From: alan.story@hertfordshire.gov.uk  
Sent: 18 April 2019 09:39  
To: Planning  
Subject: Planning application 6/2019/0217/MAJ - Northaw House

**Response to Planning application from Hertfordshire County Council (T and CP GDP Order 2015)**

**District ref:** 6/2019/0217/MAJ

Northaw House  
Coopers Lane  
Northaw  
Potters Bar  
EN6 4NG

Project Ref KMC-01	Rev 01
-----------------------	-----------

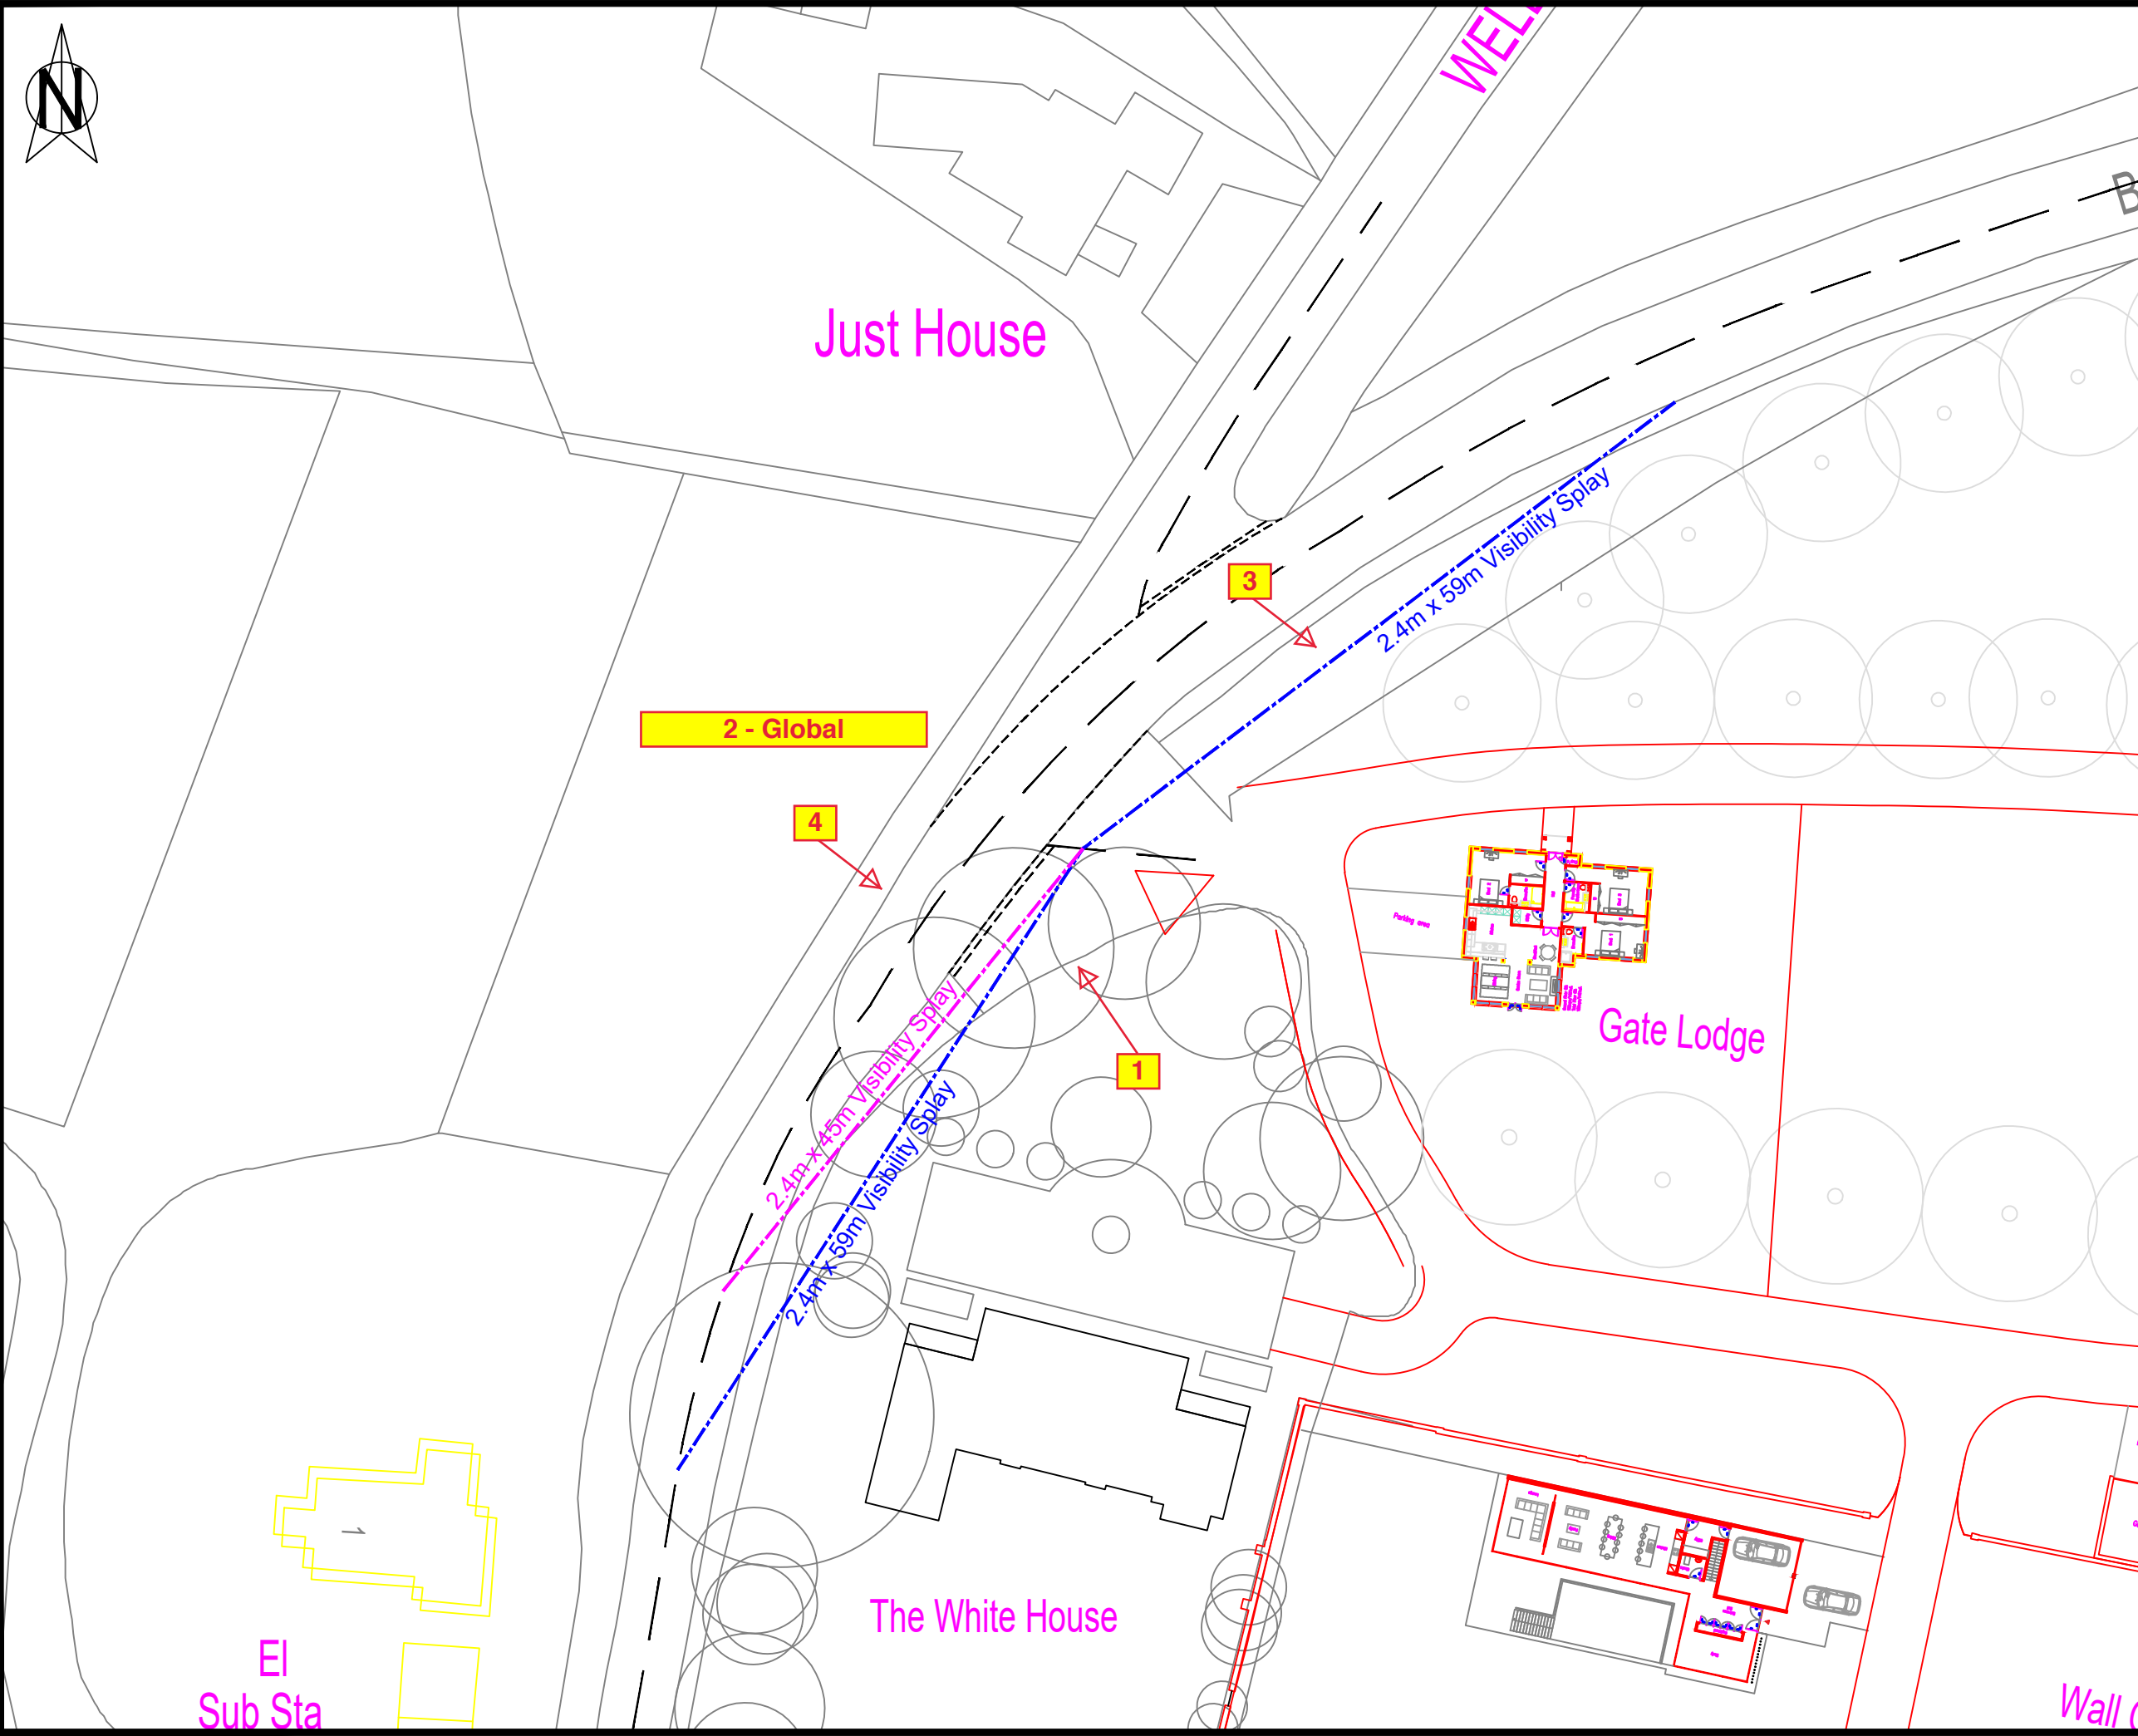
Visibility, from the western access, is assessed as deficient to MfS standards for a 40mph road, however the application is supported by speed survey data indicating that 85% 'ile speeds are measured at 35mph. It is therefore recognised that the western access, despite a number of minor improvements (junction radii / improved road marking / slow markings on approach to the bend) has visibility beneath that required. The use of MfS visibility splays is correct recognising that the County Council identifies within Roads in Hertfordshire: Highway Design Guide 3rd Edition Section 1: Policy Information and General Guidance Chapter 1 that MfS recommendations may be used on roads with 37.5 mph (60kph) or lower actual (85th percentile) speeds.

It is recognised that drawing KMC-01 rev 01 incorrectly identifies the visibility splay. Visibility splays, as directed by MfS are measured to the kerb face, whereas KMC-01 measures to centre line. At this point on Coopers Lane no physical measure prevents vehicles overtaking. Actual visibility would therefore be measured as 49m to kerb face, or 52m to a point that vehicles would be expected to be (MfS2).

3) Prior to the first occupation of the development hereby permitted a visibility splay shall be provided in full accordance with the details indicated on the approved plan number (KMC01 rev 01 and KMC02 Rev 01). The splay shall thereafter be maintained at all times free from any obstruction between 600mm and 2m above the level of the adjacent highway carriageway.

Drawing Ref KMC001 - 01 (Sheet 2 of 2)	Rev 02
---	-----------

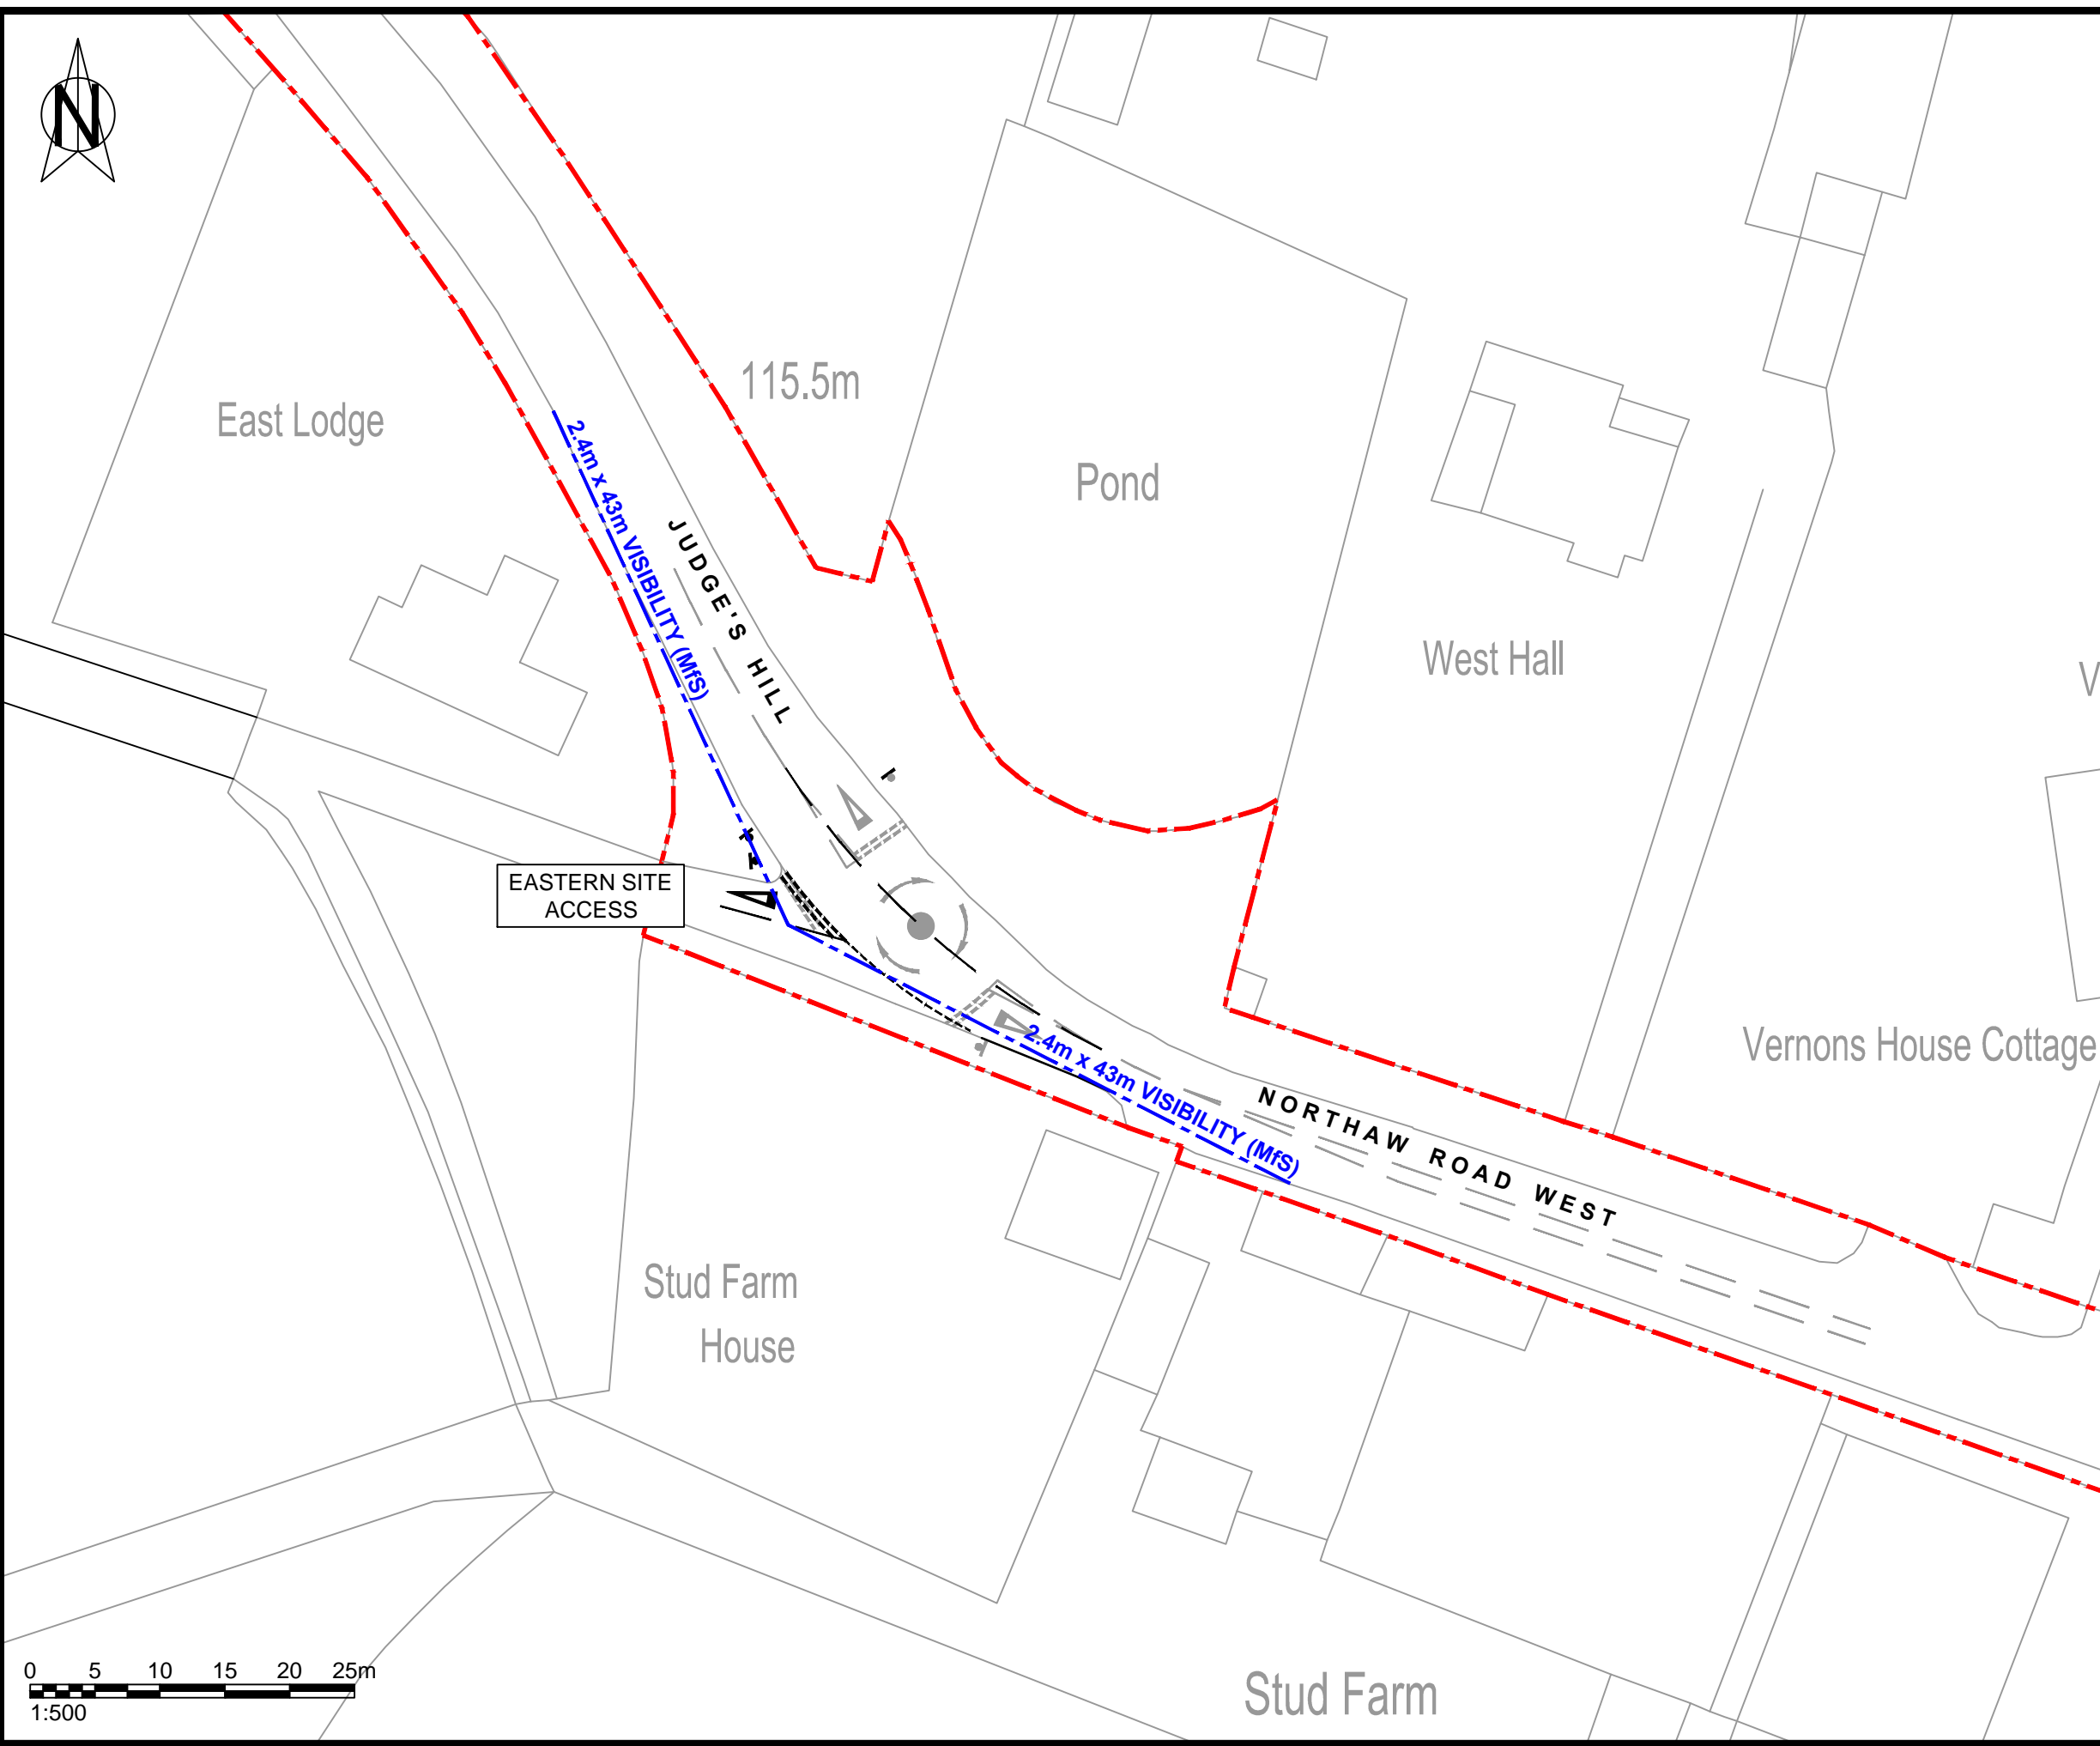
Visibility from the eastern access is sufficient for the posted vehicle speeds (43m SSD adjusted in both directions). The proposed junction changes (removal of miniroundabout and replacement with priority junction) is deemed acceptable to the Highway Authority. Such improvements also include hardening of carriageway edge for improved definition, and replacement signage (to TSRGD) for road humps, and associated lining.

Improvements to the Western Access are also found to be agreeable to the Highway Authority. Access width is reduced to encourage slower vehicle speeds into the site, whilst simultaneously reducing the distance that pedestrians are within a point of conflict with vehicles. Lining on highway shall be refreshed (slow markings / centre line).

i) Concurrent with the improvements to points of access (as condition 2 below), all off-site highway works shown on drawing KMC001-1 Rev 2 shall be delivered to the satisfaction of the Highway Authority, and shall also include improvements to NE bound and SW bound bus stops local to the site to provide Kassel kerbing. Reason: To ensure that sustainable travel options associated with the development are promoted and maximised to be in accordance with Policies 1, 3 and 6 of Hertfordshire's Local Transport Plan (adopted 2018).

2) Prior to the first occupation hereby permitted vehicular accesses (indicated for improvement on drawing number (KMC001-1 rev 2) shall be reduced in width and provided with kerb radii as shown. Prior to use arrangements shall be made for surface water drainage to be intercepted and disposed of separately so that it does not discharge from or onto the highway carriageway.
